5 July 2018

Revised Response to Submissions - Frederick Street, St Leonards Tower B Stage 2 (SSD 8894)

DESCRIPTION
LEVEL 2A & 3B

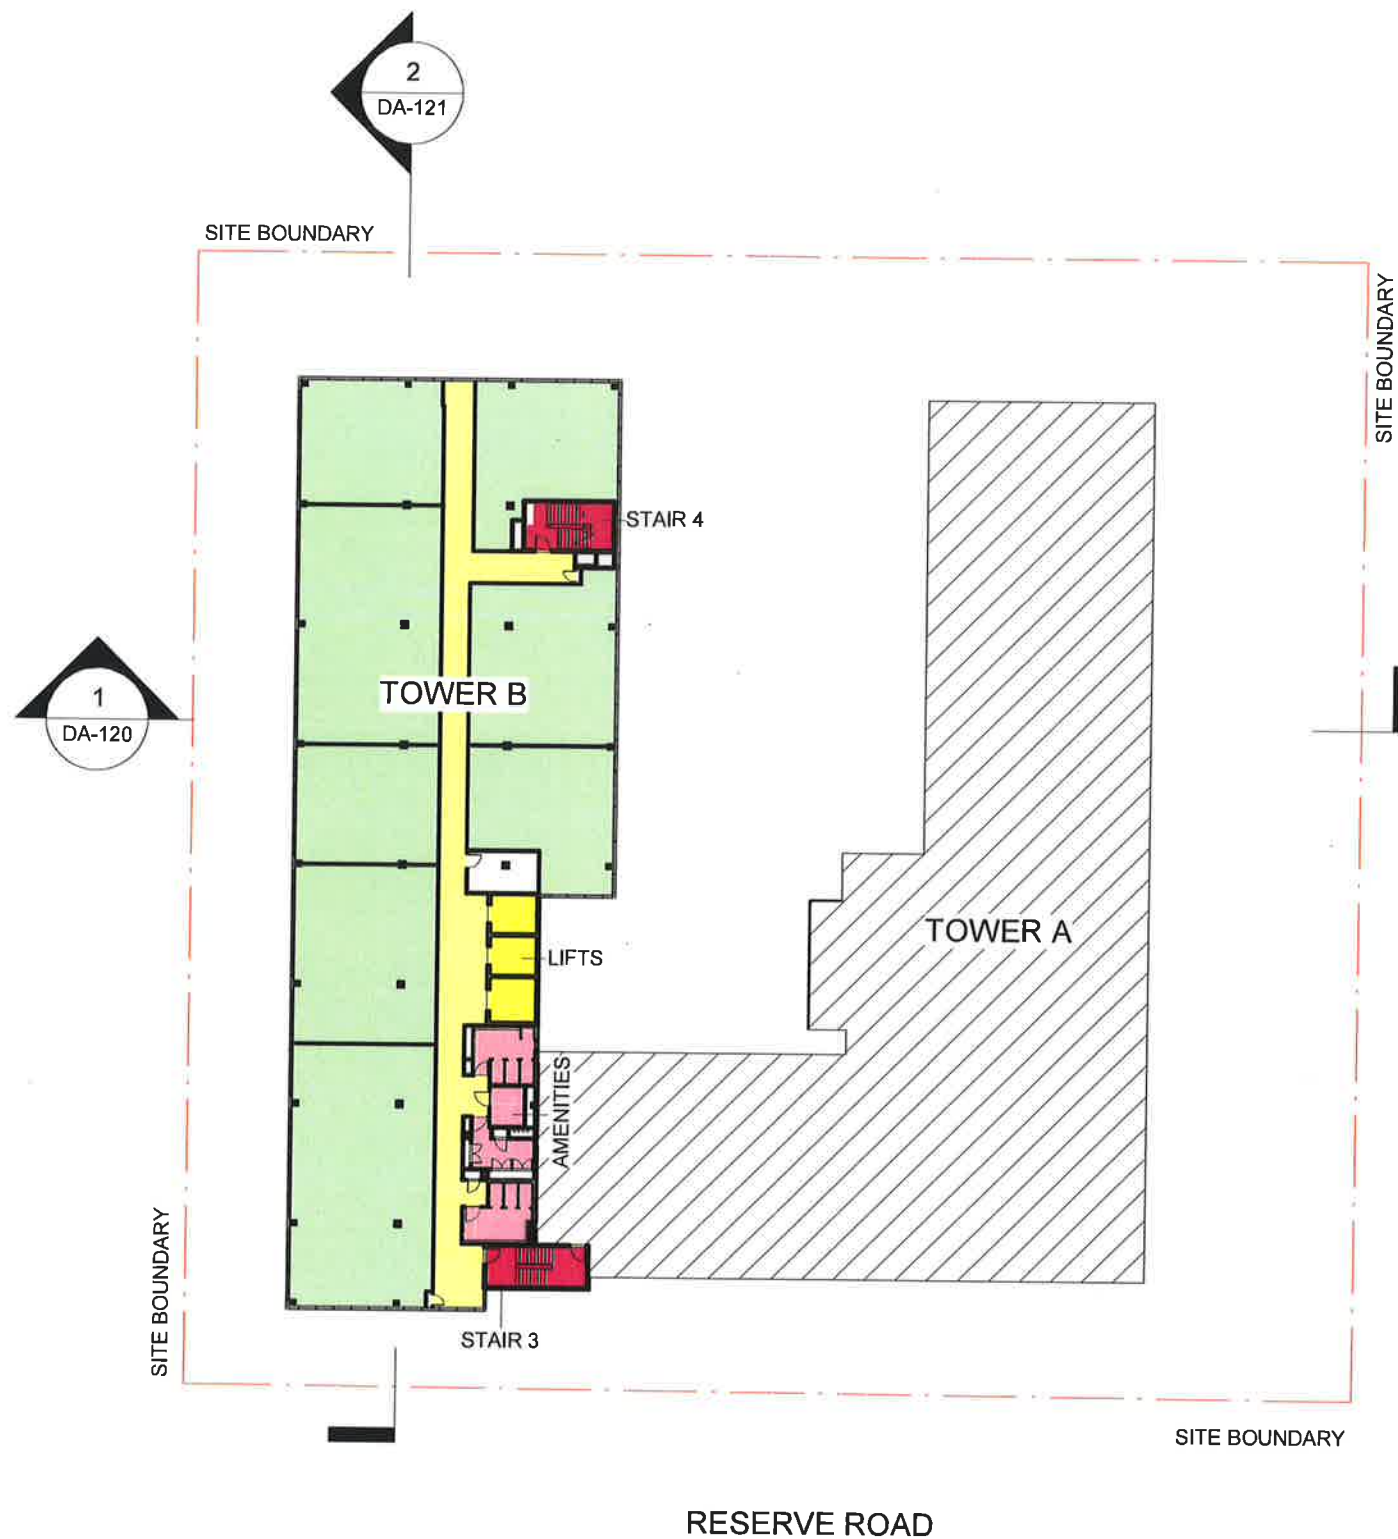
Detailed floor plans for Levels 2, 3 to 6 (inclusive) and 7 to 9 (inclusive) must be submitted. Where relevant, access between Levels 3 to 6 of Tower A (SSD 7543) and Levels 3 to 6 of Tower B are to be shown. It is noted that Tower B would only comprise the extension of 'Stair 4' and the lift column from Level 2 and the extension of 'Stair 3' from Level 7.

Amended plans have been prepared by Billard Leece Partnership Pty Ltd (Attachment 4).
